Ribble Valley Borough Council  
Development Control

Application: 3/2020/0932

Application Site: Ashcroft, Mill Lane , Waddington

Proposal: Demolish existing dwelling and erect new 4 bed dwelling

existing site plan 1:200

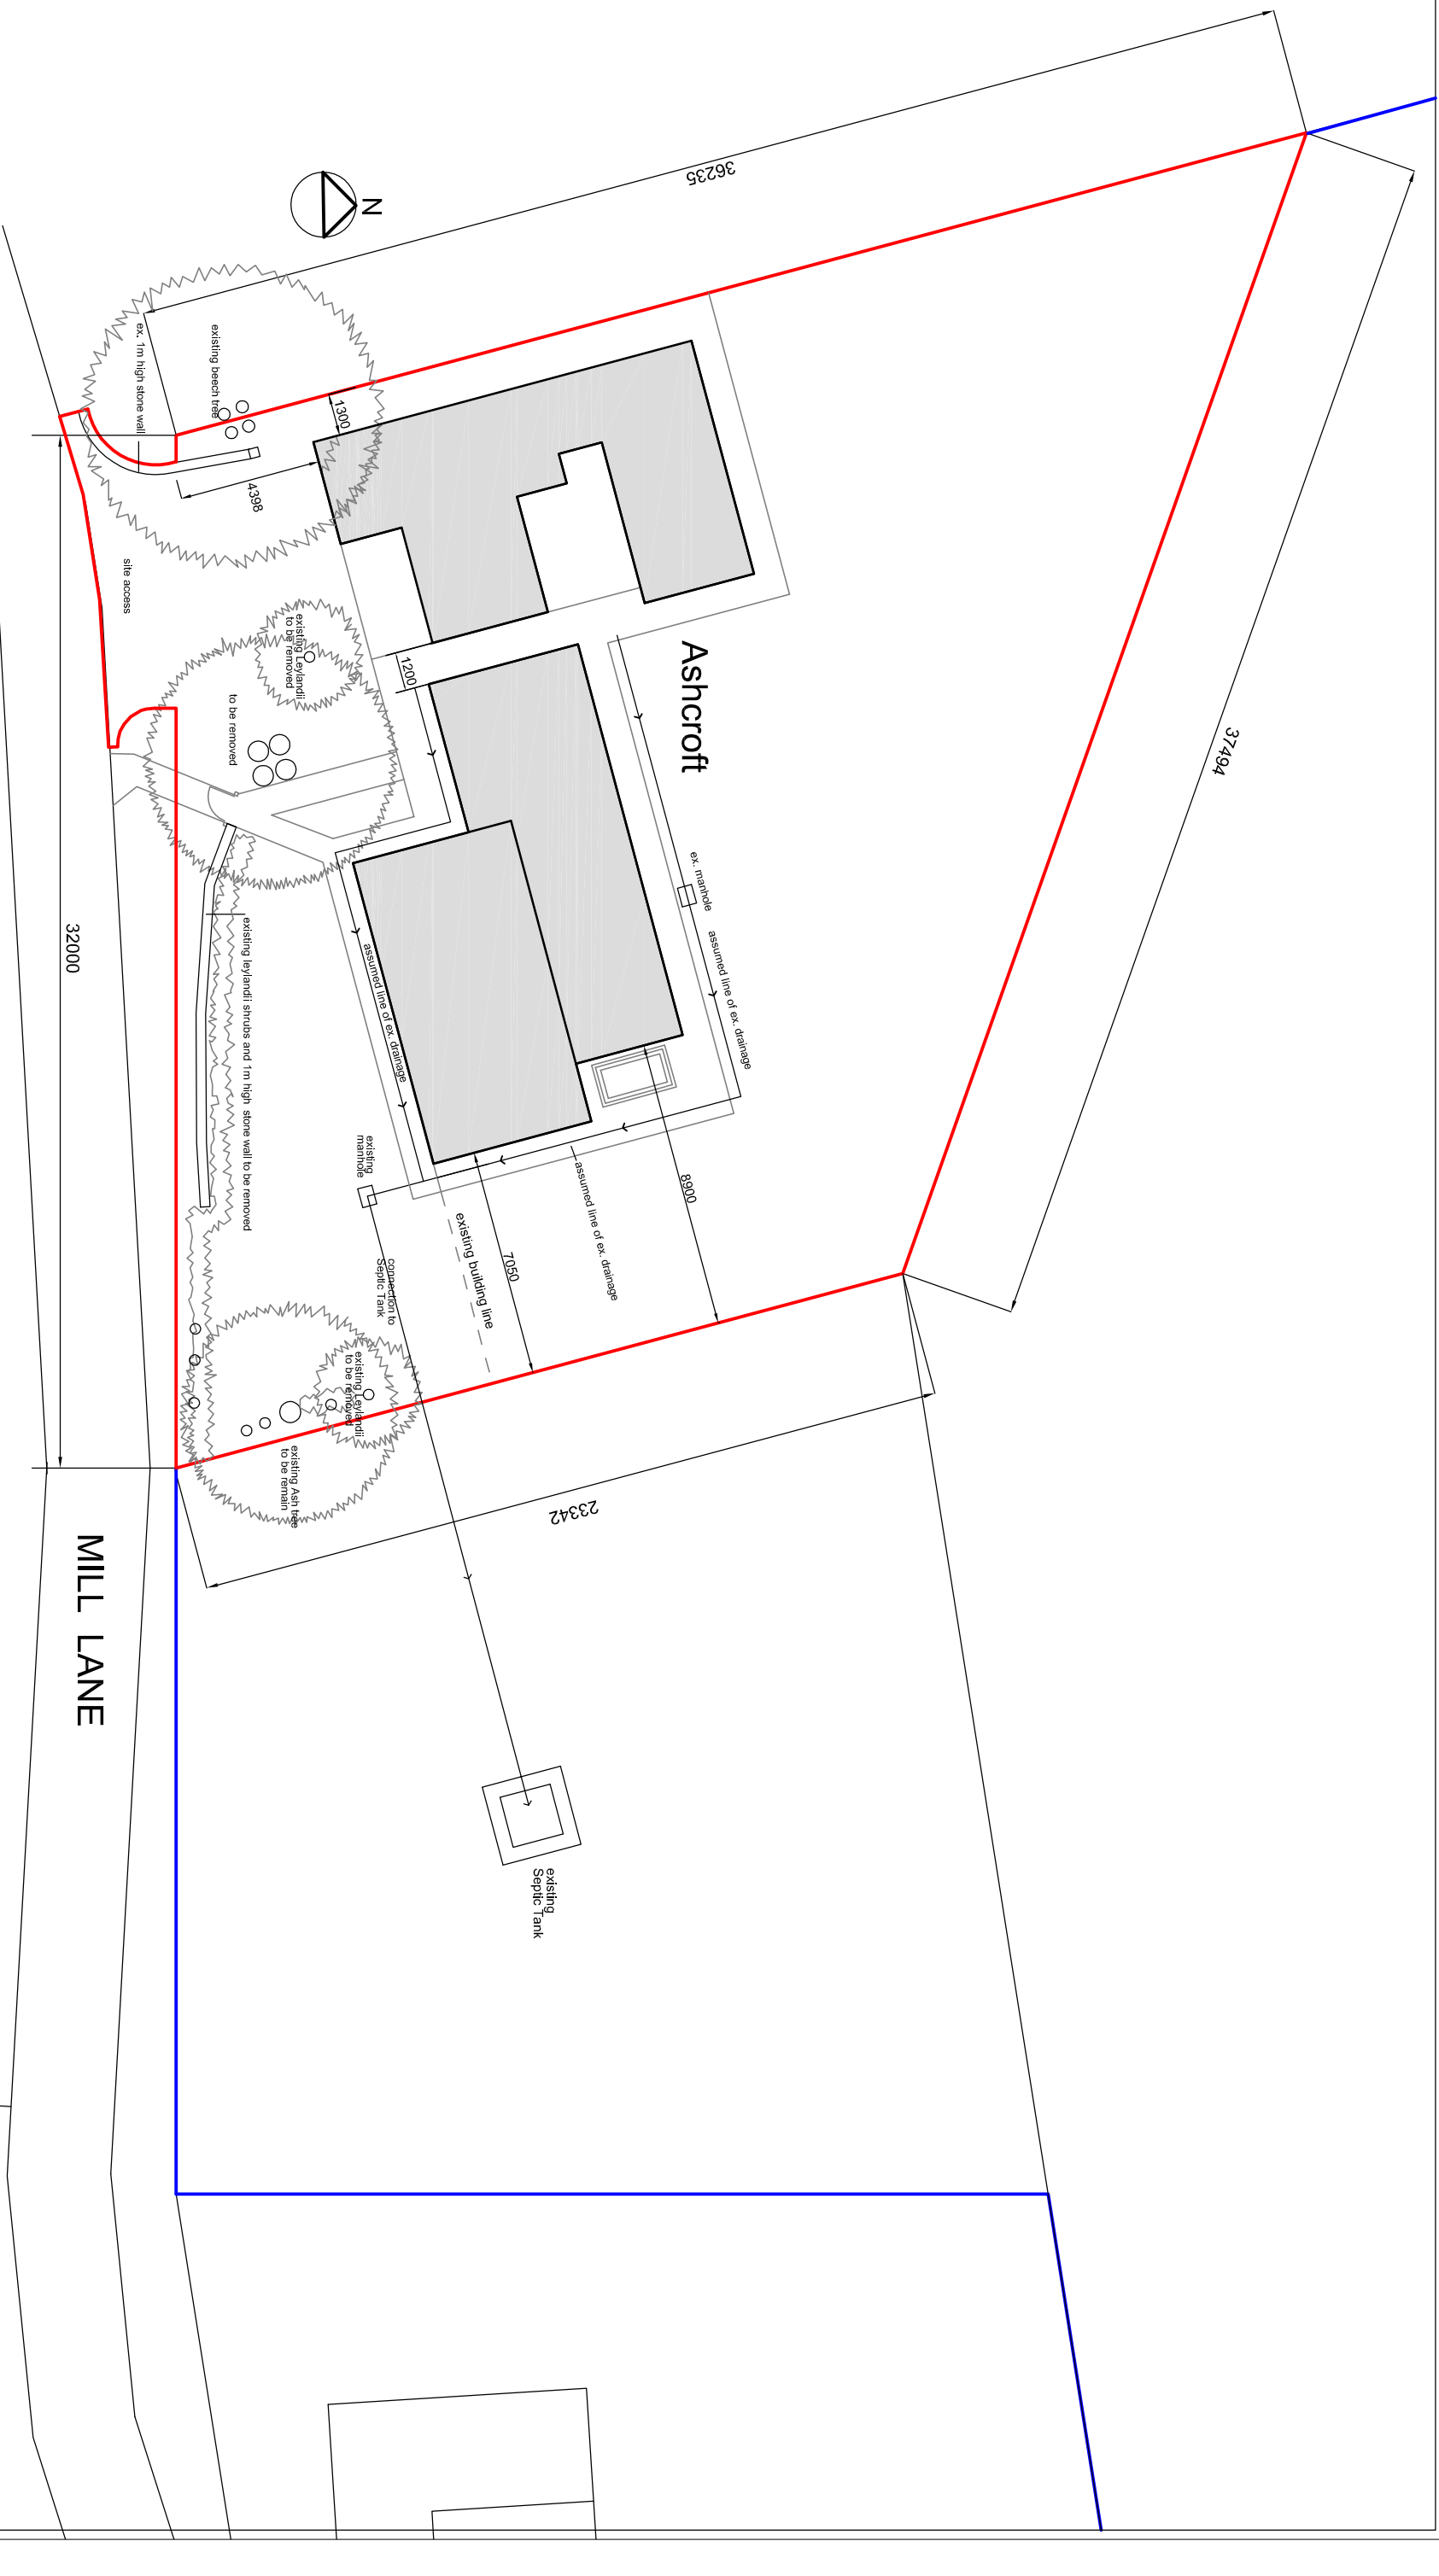
- The erection of the new dwarf wall to the east of the site access may alter / divert the existing drainage course from the site. Any surface water emanating from the site should be intercepted to avoid discharge on to the carriageway.
- The site access via Mill Lane is restricted I would therefor suggest the imposition of the following conditions to any permission that may be granted to ensure that Mill Lane is not obstructed by vehicles associated with the demolition / reconstruction

1 No development shall take place, including any works of demolition or site clearance, until a Construction Management Plan (CMP) or Construction Method Statement (CMS) has been submitted to, and approved in writing by the local planning authority. The approved plan / statement shall provide:
